Submission on Sirius Development Application (SSD10384) from Save Our Sirius Inc (SOS)

As the architect of the building, Tao Gofers, says in response to this proposal: “My preference would be that no amendments are made to the existing building.” That would be our preference also, and in particular that the reuse of the building for social and affordable housing should be considered.

DWG. TITLE  
**Consolidated Groundfloor / Public Domain Plan**  
 PROJECT  
**SIRIUS SITE, 2-60 CUMBERLAND ST, THE ROCKS**

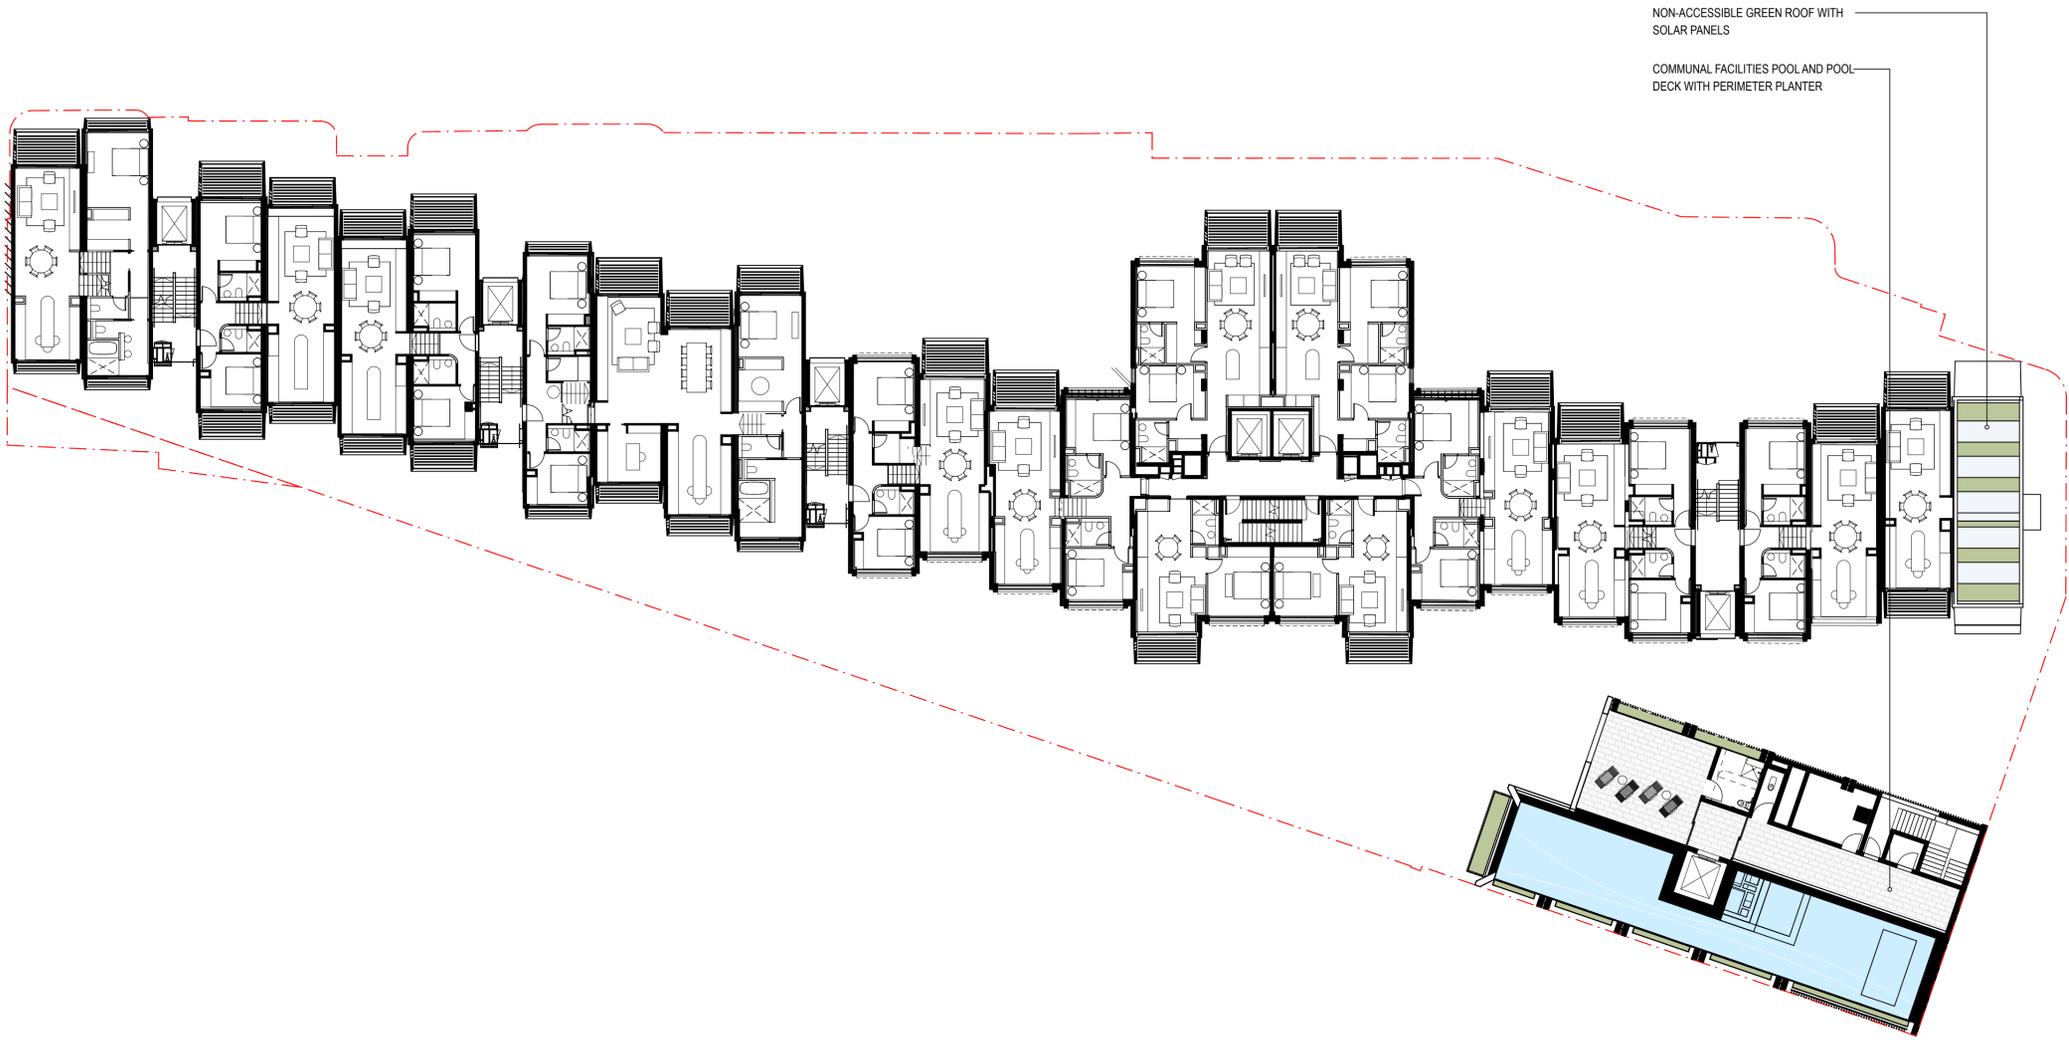
- The through block link from Cumberland Street to Gloucester Walk should be conditioned to be available for public access at all times.
- The comments of the Design Integrity Panel requesting retention and public use of the Phillip Room should be enshrined in an appropriate condition and be included in the proposed Operational Plan of Management.
- The new height limit for Sirius should not be taken as an excuse to extend height limits in the vicinity. This is a unique and historical situation.
